Application No: FG/29/22/HH
Site Address: 14 Ocean Drive Ferring BN12 5QJ
Description of works: Part two storey part single storey rear extension.

Thank you for your internet representation made on 23rd March 2022 which has been recorded as an objection with the comments as follows:

Proposed Rear Elevation

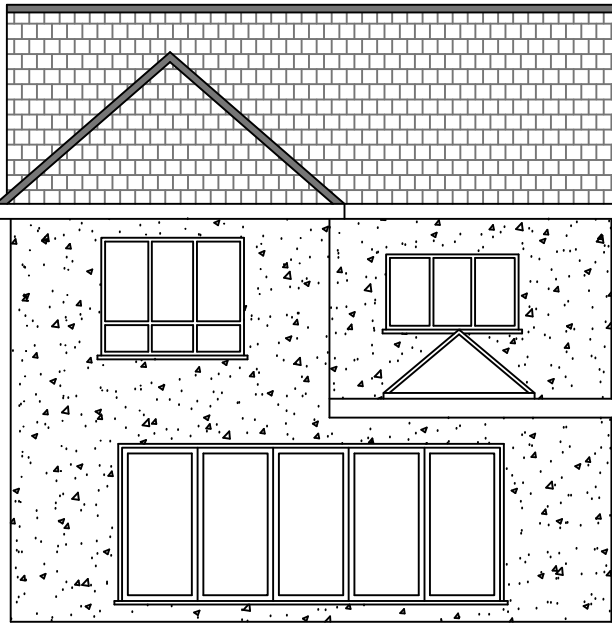
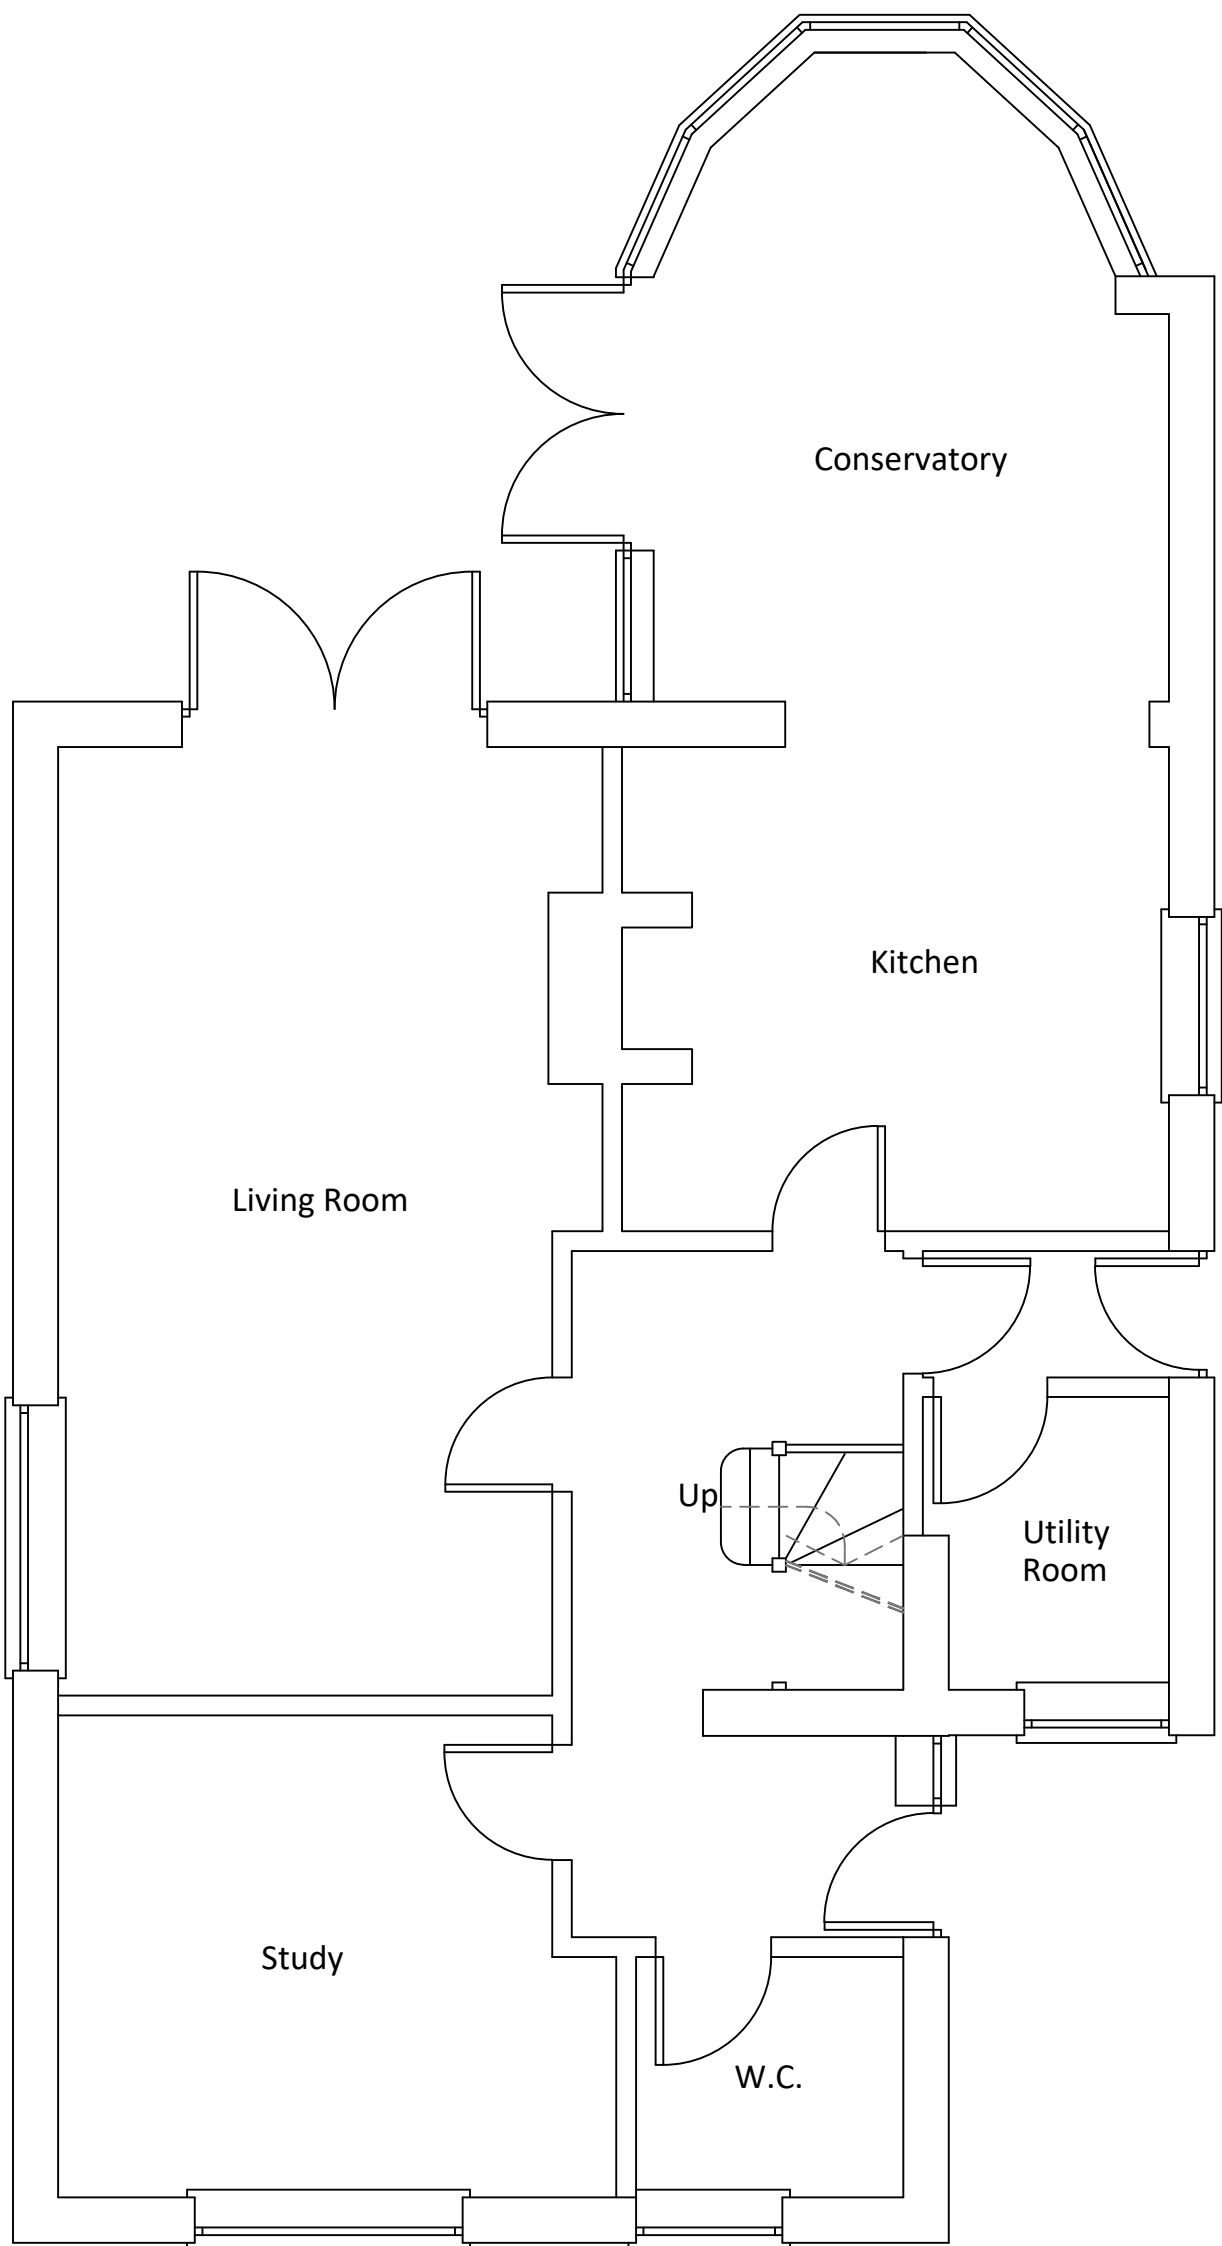
I wish to object to the above planning application on the basis that the proposed two story element would block all direct sunlight at certain times of the day to our Dining Room and kitchen which windows face due south. Additionally, the extension would certainly cause shading and loss of light continually to these rooms. I would therefore ask the Planning Department to consider the 45 degree Rule and also the Right to Light Act.
